Located At 190 VALLEY ST

Job ID: 2012-03-3537-ALTCOMM

has permission to Add underground Drainage Along Valley Side of building  
provided that the person or persons, firm or corporation accepting this permit shall comply with all of the provisions of the Statues of Maine and of the Ordinances of the City of Portland regulating the construction, maintenance and use of the buildings and structures, and of the application on file in the department.

Re: Florence House

DATE: 3-29-12
 SCALE: AS NOTED
 DESIGN BY: JAT
 DRAWN BY: RSC
 FILE #: 11388-S101.dwg
 PROJECT NUMBER:
11388
 SHEET NO:
S101

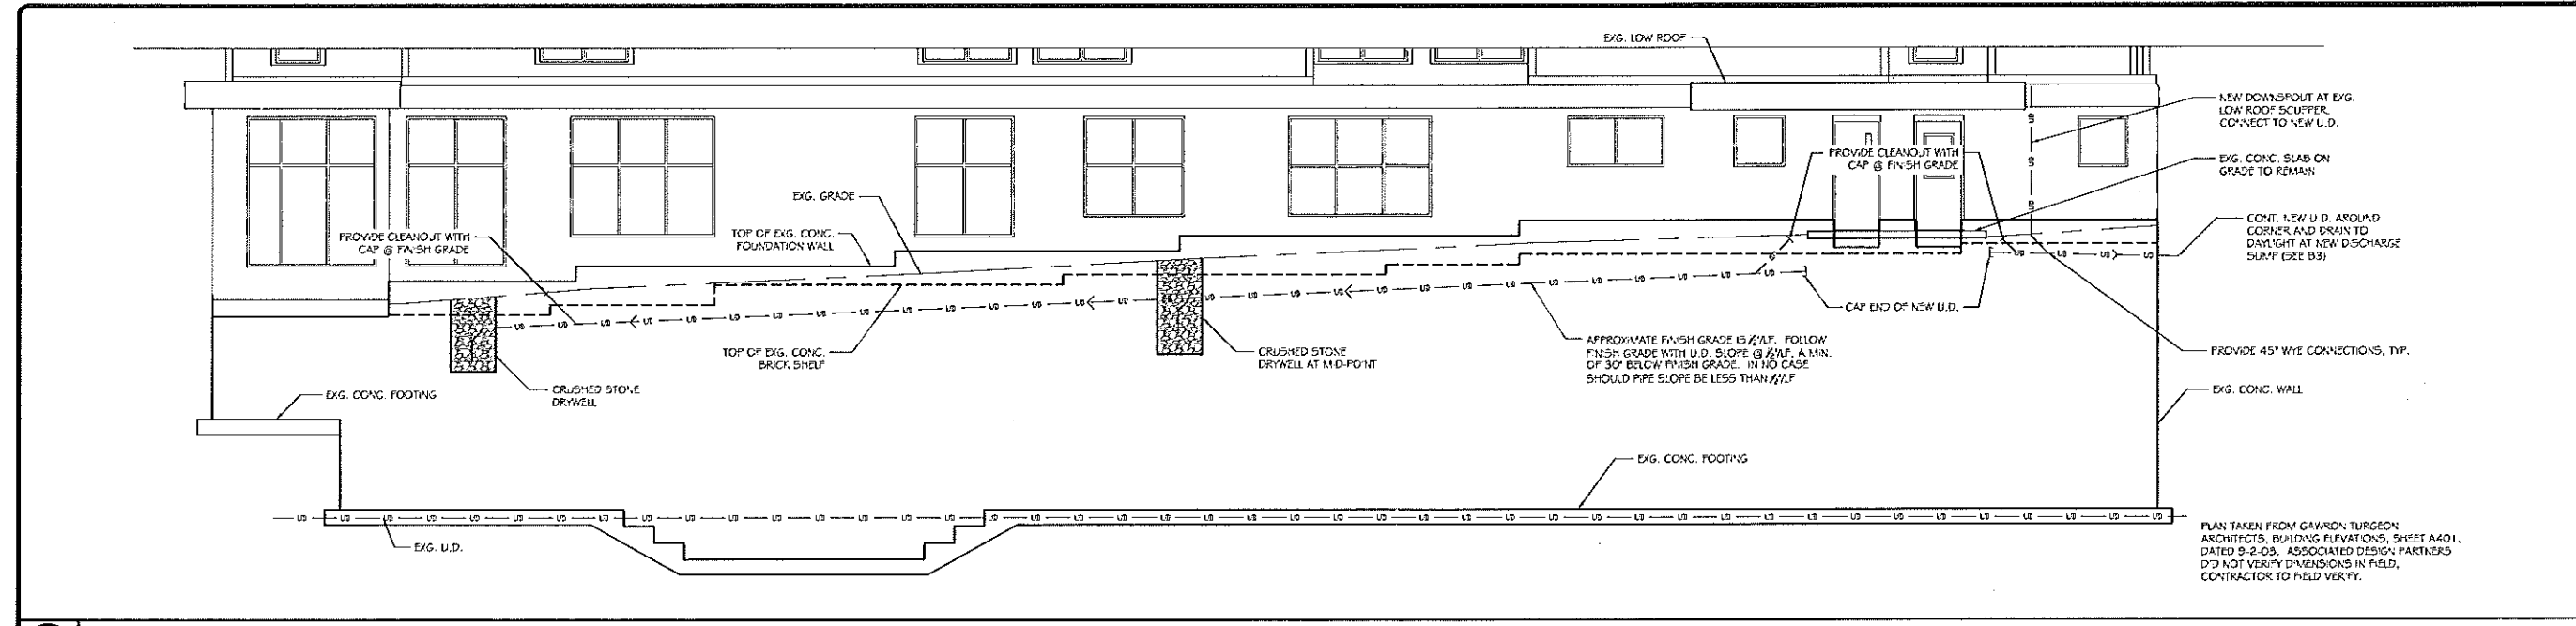
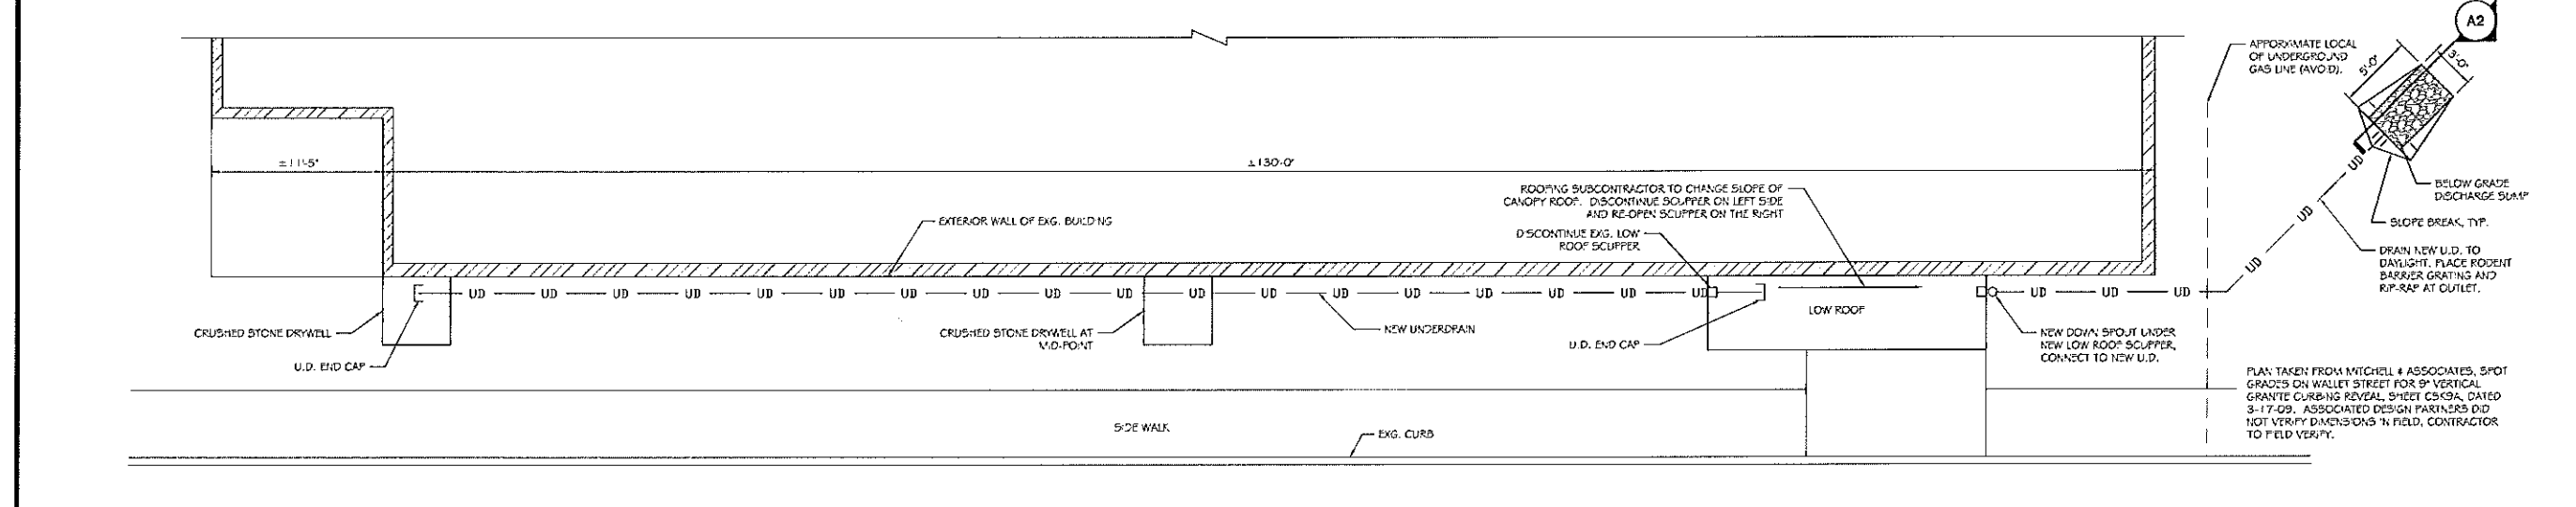
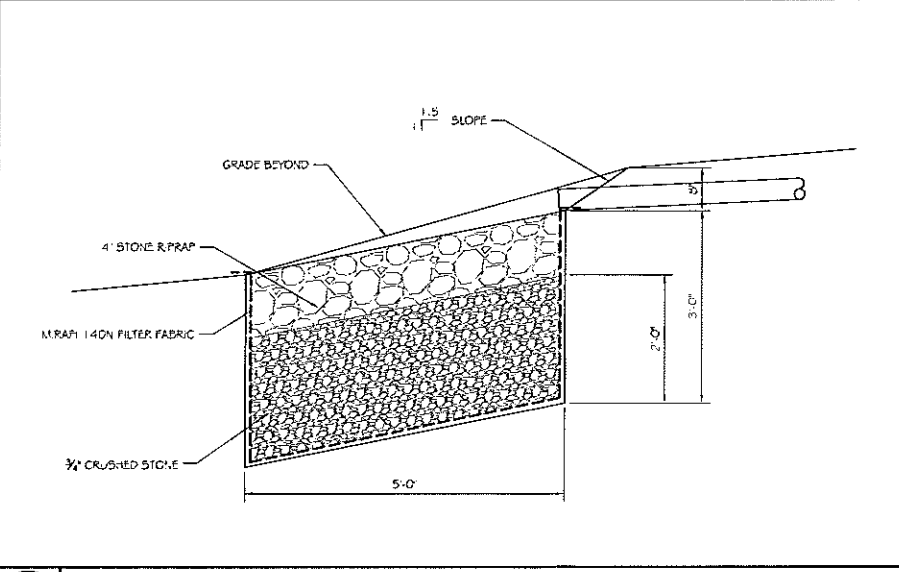
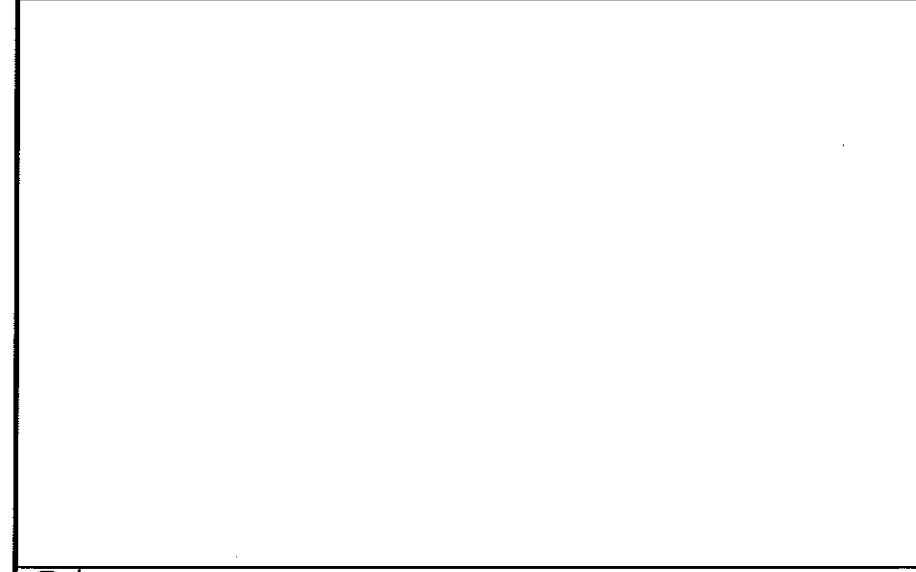
It is my understanding that The City of Portland and an AVESTA investor have requested clarification of some issues regarding the proposed drainage running from the canopy roof, to the right side of the building, which then potentially discharges onto the vacant lot.

Specifically I have been requested to address the following issues;

1. Verification that the proposed drainage system outlet will not cause any significant erosion. Given the very small catchment area, which is limited to the side entrance canopy roof and a small area between the canopy roof and end of the building, the amount of flow anticipated through the pipe and concentrated at the discharge is expected to be very minimal; furthermore, to ensure that no significant erosion is created at the discharge outlet we are proposing the contractor install a below grade discharge sump consisting of a 3 foot wide x 3 foot deep x 5 foot long hole lined with filter fabric, filled with 2 feet of  $\frac{3}{4}$ " crushed stone and overlain by 12" of D50= 4" stone riprap. The proposed sump should be positioned beginning downstream of the discharge pipe and finished flush to existing grade.

2. The only water entering this proposed drainage system comes from the small canopy roof over the side entry door. The volume of water from this small catchment is minimal and will likely only present discharge at the underdrain outlet during a significant weather event. Most of the roof runoff is expected to dissipate into the ground next to the foundation and eventually get collected by the existing footing drain system. Addition of the below grade infiltration sump will significantly reduce and perhaps eliminate the occurrence of offsite drainage influences.

3. In the event of a new project on the abutting property, this proposed drainage system could easily connect or tie into the drainage system for the new project.

4. It would be impractical to connect or tie into the existing footing drainage system located at the foundation footing elevation, simply because the depth to the existing footing drain is too deep to unearth by normal excavation means without creating potential damages and significant impacts to the existing site and building infrastructure.
